SF2012/000358; WST07/00087/08

**SSD-10269: Lot 152 DP 816020 and others; 10 Kurrajong Creek Road, Baan Baa Narrabri Underground Mine Stage 3 Extension Project**

Thank you for referral of SSD-10269 via the NSW Major Projects Planning Portal dated 29 October 2020 inviting comment from Transport for NSW (TfNSW).

Figure 3.2: Surveyed Average Weekday Traffic by Time of Day (vehicles per hour)

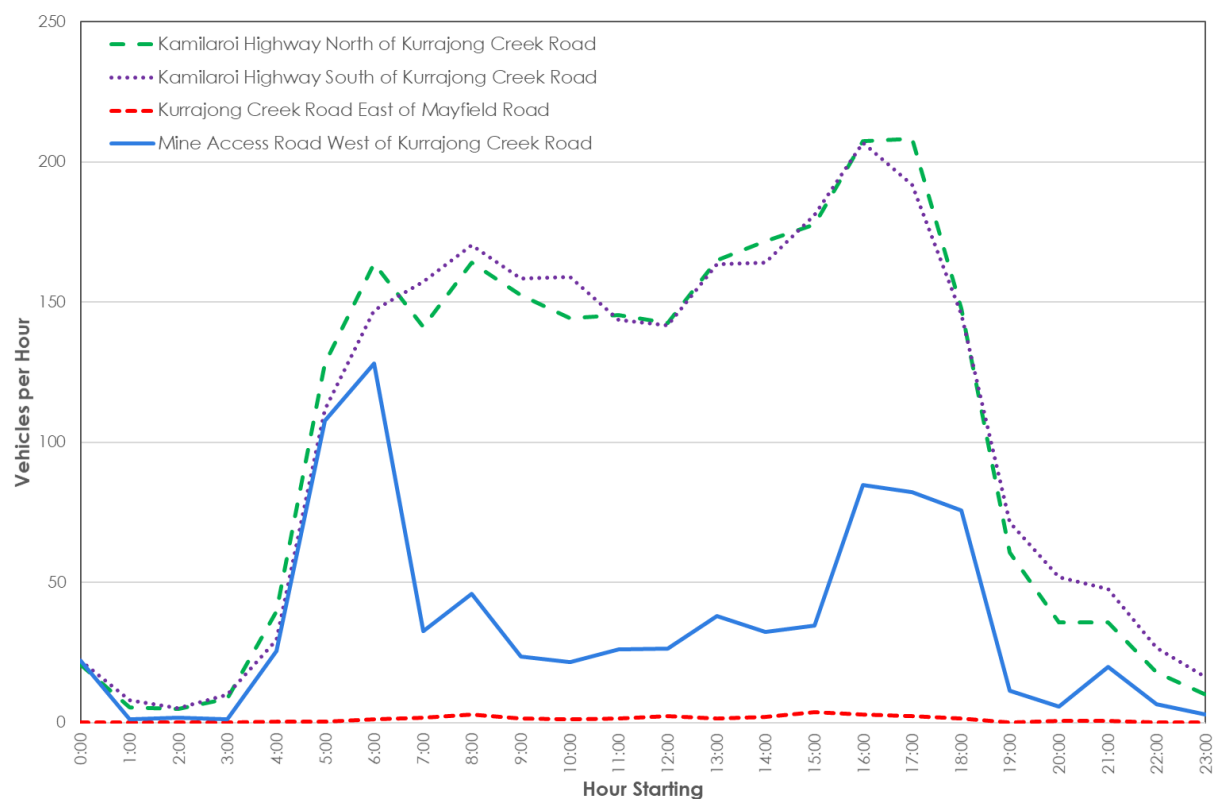
- For example, a weekday peak hourly operational shift traffic (two-way) volume of some 120-150 vehicles per hour was surveyed, along with a weekday daily total (two-way) volume of 858 movements. This is less than the minimum ~1,000 daily vehicle trips to be expected if the average occupancy rate per light vehicle is close to 1 person, plus lunch trips, deliveries, visitors and so on.
